Our Ref: BR/207/18/HH

**Town & Country Planning Act 1990 (as amended)
Town & country Planning (Development Management Procedure) (England) Order 2015
Application for Householder Planning Permission**

Development Single storey side extension
Location 84 Brooks Lane Bognor Regis

ELEVATIONS. As Prop^d

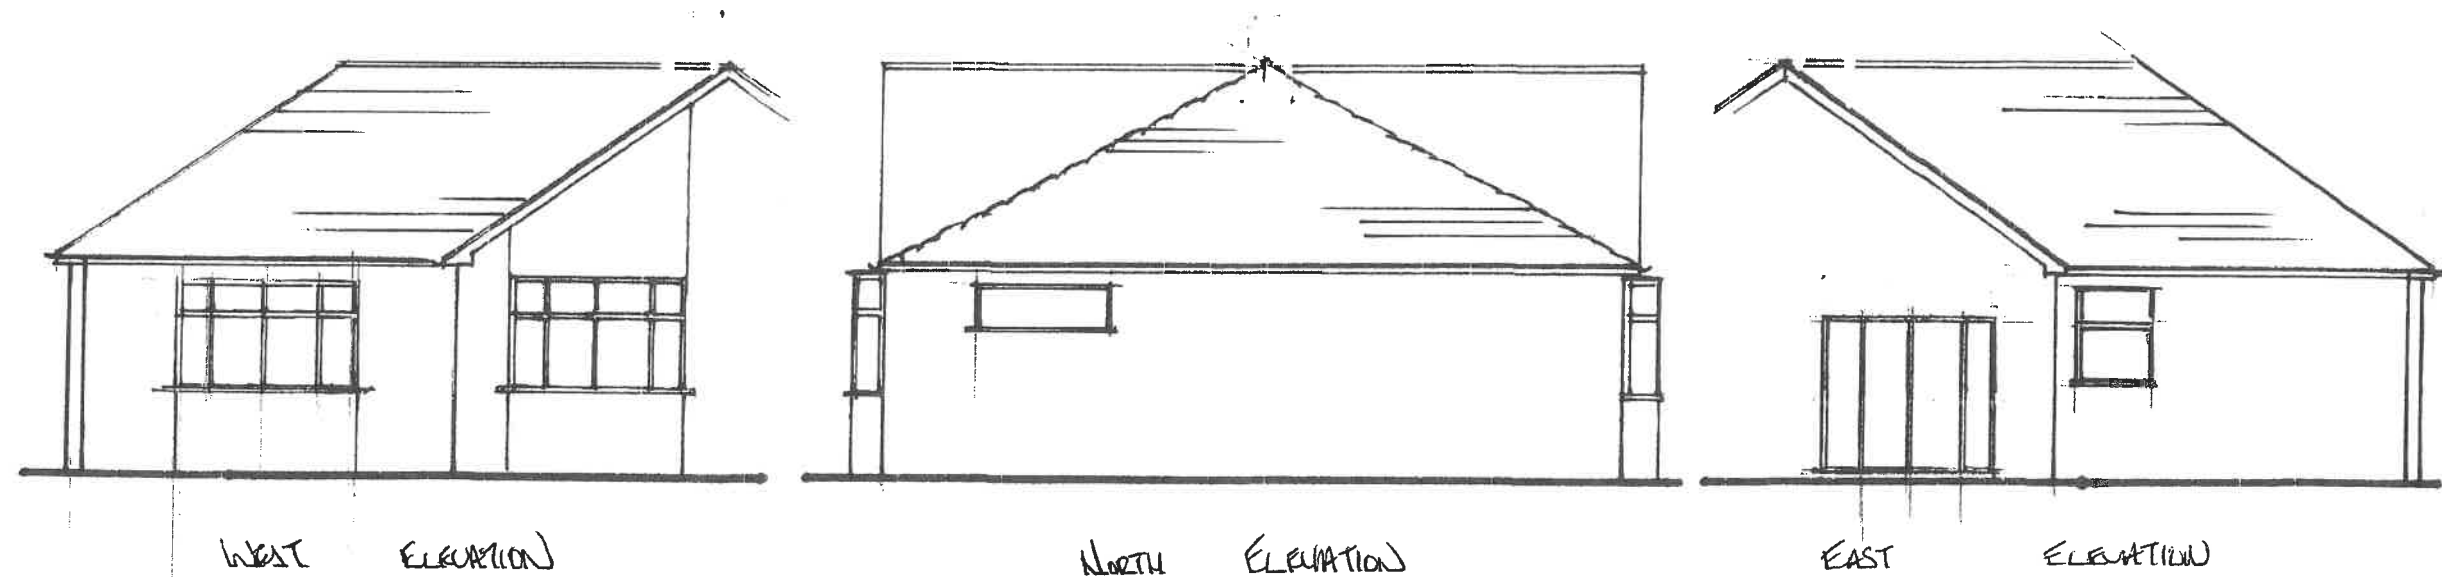
Please label the existing and proposed elevations as north, south, east or west as appropriate.
